Application Ref:	3/2025/0239			 <div>Ribble Valley Borough Council</div> <hr/> www.ribblevalley.gov.uk
Date Inspected:	01/05/25	Site Notice:	01/05/25	
Officer:	LW			
DELEGATED ITEM FILE REPORT:				REFUSAL

Development Description:	Proposed replacement dwelling following demolition of existing house and garage plus extension of the residential curtilage.
Site Address/Location:	Glendene, Barker Lane, Mellor, BB2 7EE.

EXISTING HOUSE ELEVATIONS AT 1:100

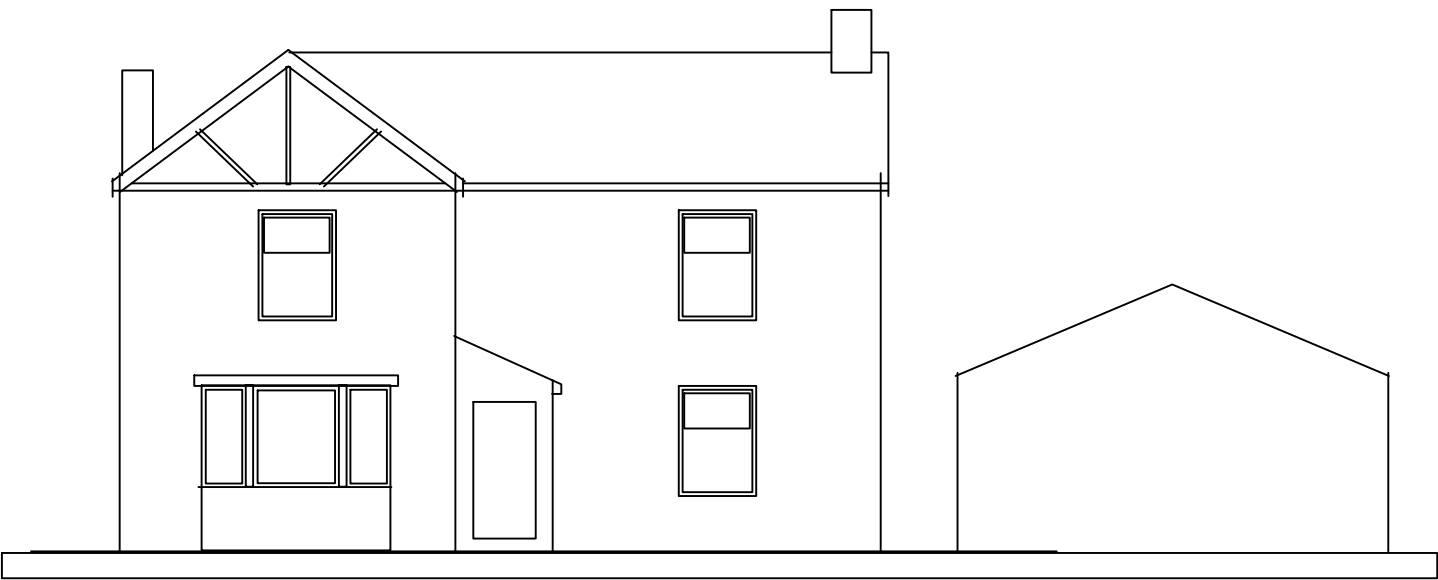
The proposed scheme has been amended since pre-application, with the development now including a two-storey dwelling with a gable roof form, measuring a maximum of 11.5m by 12.6, along with a single storey integral garage, utility and sitting area measuring 4.7m by 14.5m. The Agent has provided a comparison of volumes taking account of the existing dwellinghouse (385 cu.m), inclusive of the detached garage building, and the proposed replacement dwelling (740 cu.m). These calculations indicate that the proposal would result in a total amount of new built form of 355 cu.m, equating to an increase of approximately 92% above that of the existing buildings. The proposed development would therefore clearly result in a materially larger building at the proposal site than that of the existing. Furthermore, the prominent views into the site, particularly upon approach from the south along Barker Lane, would mean that the resultant increase in volume would be apparent from the surrounding landscape.

With the above in mind, it is considered that the proposed replacement dwelling would result in a materially larger building than that of the existing in as much that the cumulative cubic volume increase of the proposal would be significant in relation to the existing property which in turn would result in Green Belt harm contrary to the guidance set out in Paragraph 154 of the NPPF and Key Statement EN1 of the Ribble Valley Core Strategy. Furthermore, there are no very special circumstances demonstrated which would outweigh this harm.

PROPOSED ELEVATIONS

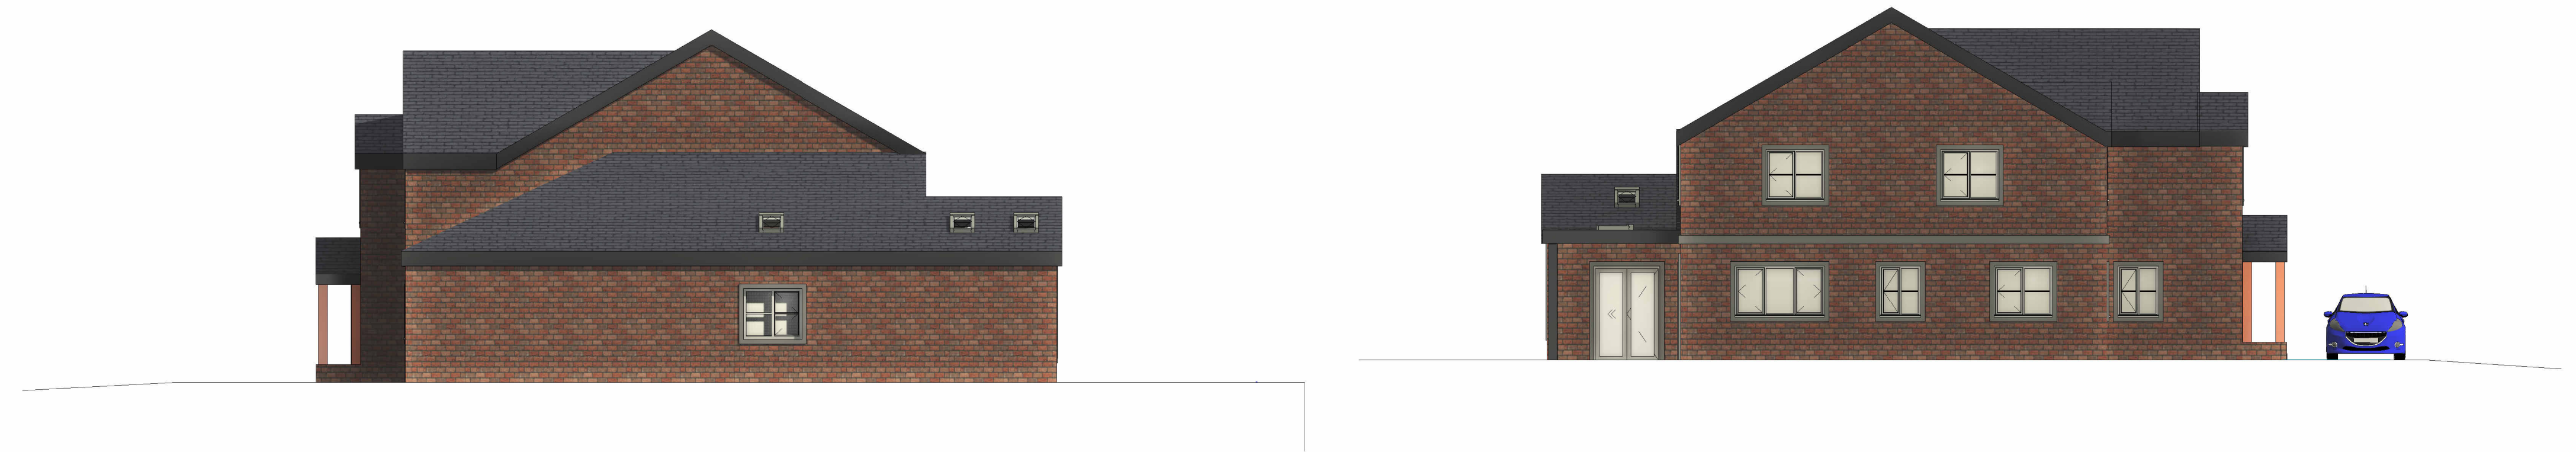
The two-storey dwellinghouse would measure 11.5m by 12.6 and would incorporate a single storey integral garage, utility and sitting area to the northern side elevation, measuring 4.7m by 14.5m. To the rear a flat roof canopy would also be featured, along with an entrance porch to the front. The property would have a maximum eaves and ridge height of 4.8m and 7.9m respectively and would be constructed from facing brickwork with stone features, slate roof tiles and uPVC windows and doors.

The window openings to the front and rear of the dwelling would provide similar views to those afforded by the window configuration featured to the existing property, whilst the openings to the southern side elevation would not have a direct interface with any nearby residential receptors and would provide views largely towards the open fields which border the site to the south. As such, no new opportunities for direct overlooking or loss of privacy are anticipated in this respect. The window proposed to the northern side elevation would face towards Hillside, however this window would serve a utility room and therefore could be obscurely glazed in order to protect the amenity of the adjacent residential property and reduce any perceived sense of overlooking.

The proposed replacement dwelling would appear relatively traditional in design, utilising facing brickwork with stone features, slate roof tiles and uPVC windows and doors. As such, it is not considered that the proposal would appear at odds with its surroundings, with the external facing materials of the dwelling appearing similar to the existing properties in the locality.

PROPOSED FLOOR PLANS

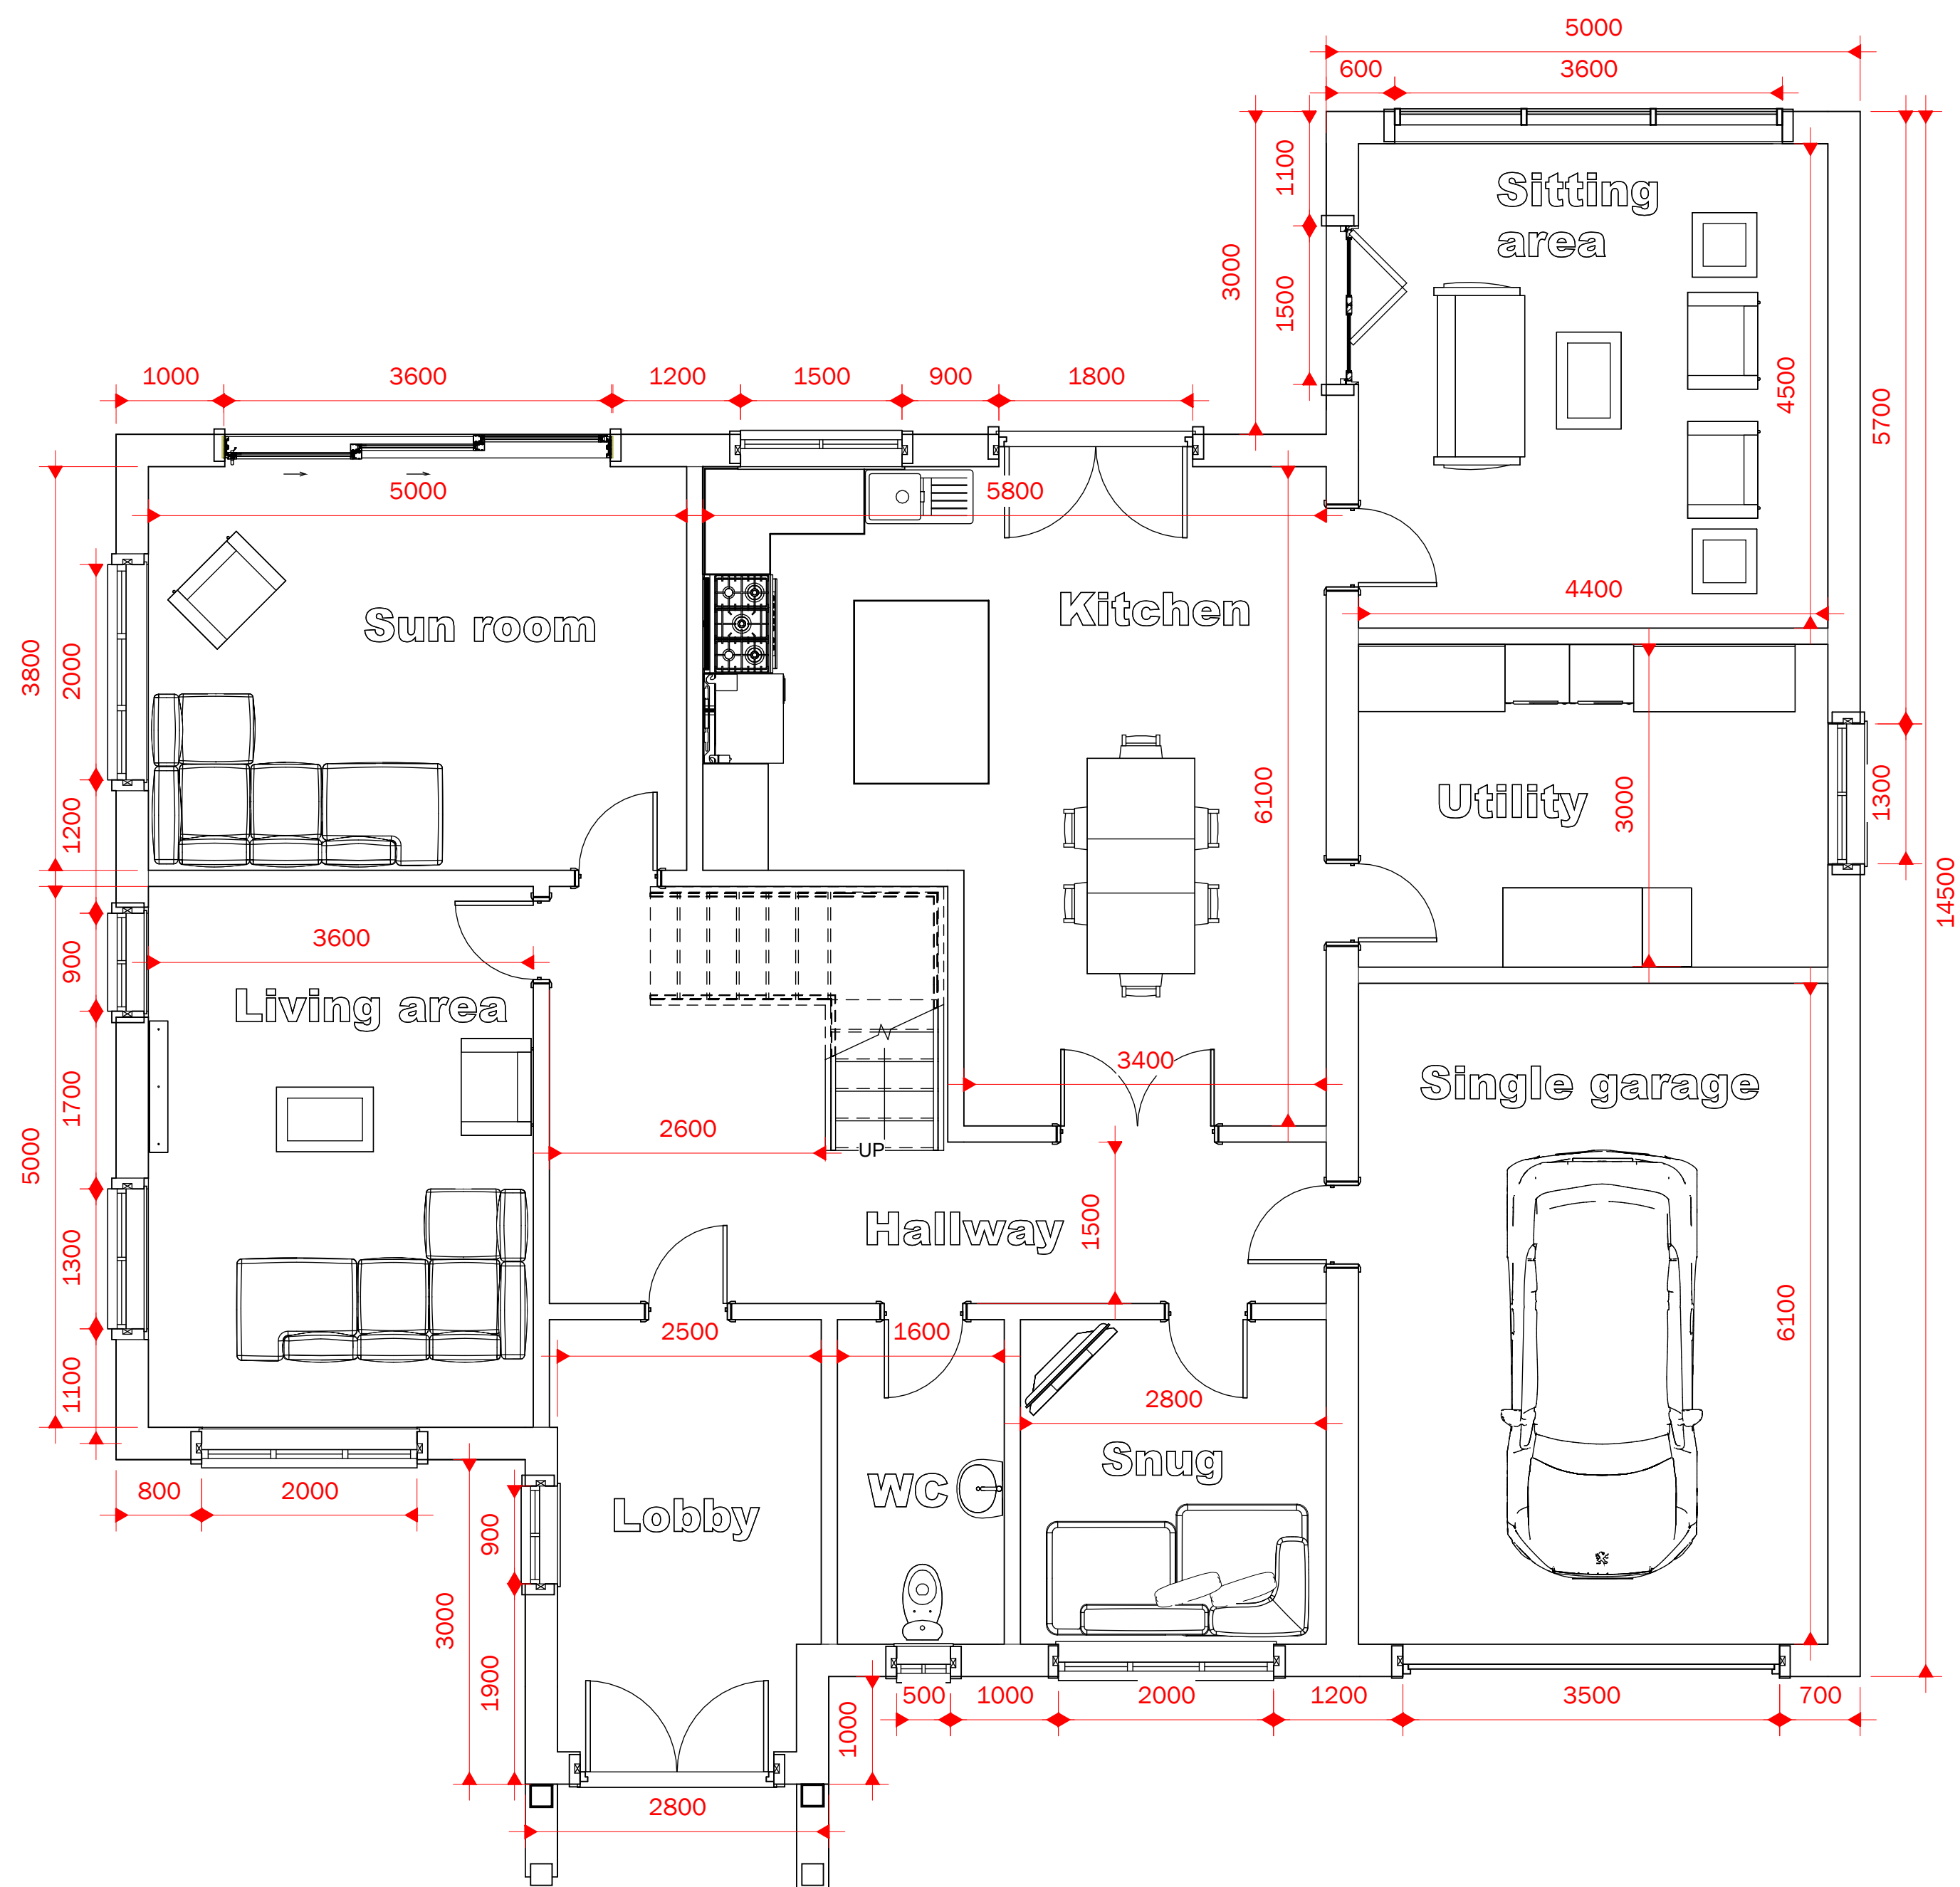
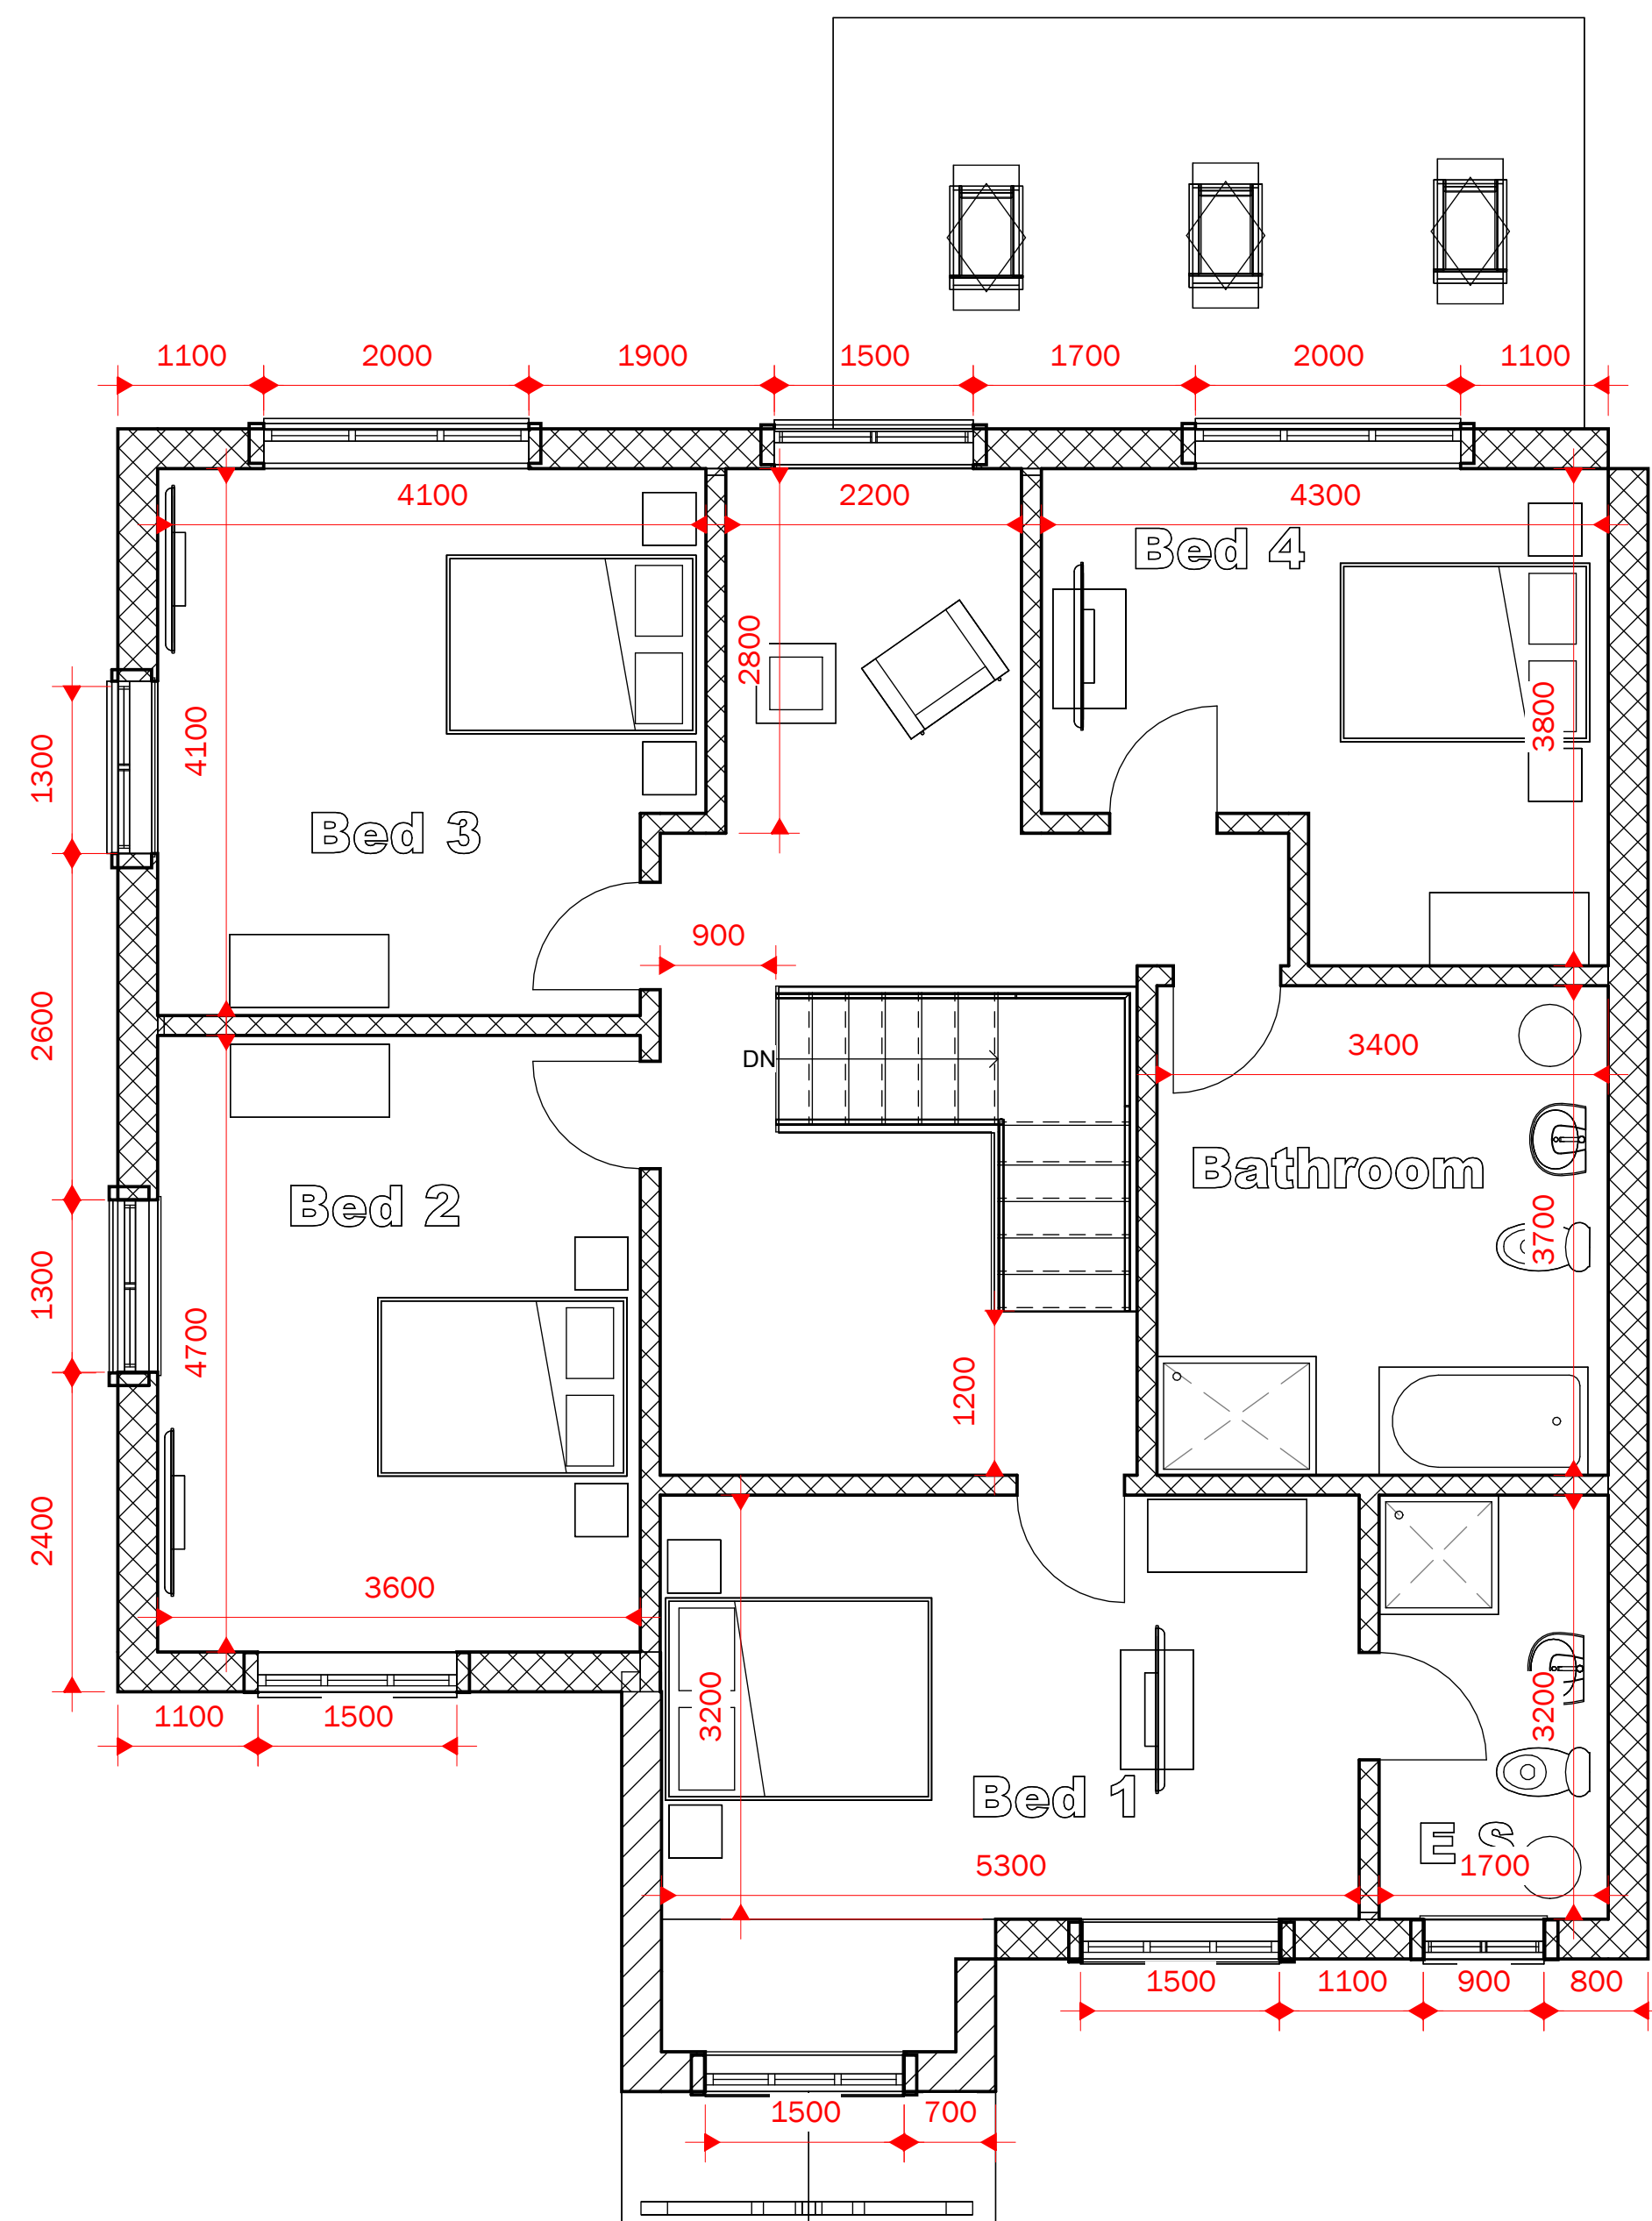
However, the submitted site plans show the proposed replacement dwelling to encroach onto the grassed area to the rear of the existing property, with the proposed parking area also resulting in the partial loss of the grassed area situated to the front of the existing dwellinghouse. Based on this, the cumulative loss of natural habitat appears to exceed the 25 sq.m de minimis threshold.
